Please find enclosed my Observation on the proposed Ballyfasy Wind Farm/Case Reference number – PAX10.323957.

Application Name: Balyfasy Wind Farm

Case Reference: PAX10.323957

**FORMAL OBJECTION TO PROPOSED BALYFASY WINDFARM**

11474-2061

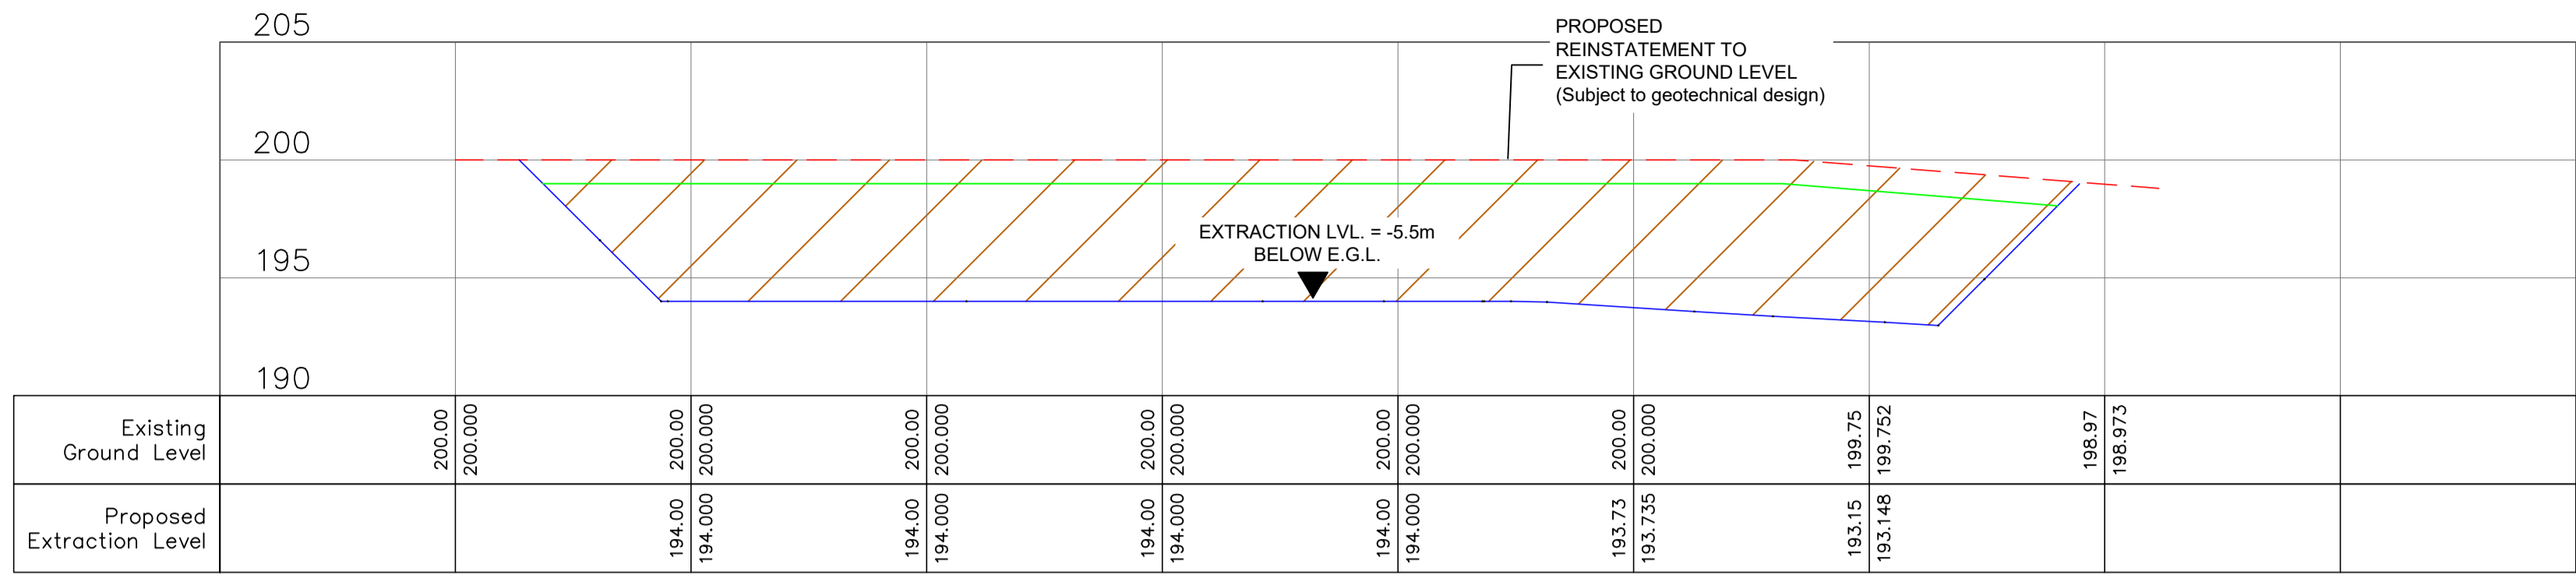
I was unaware of proposals which change the road layout- as per drawing No 11474-2061. The proposed changes will make my home vulnerable to traffic colliding with my property and there will be increased risk of damage and loss of life. I was never consulted as to these changes and I own property at either side of the road.
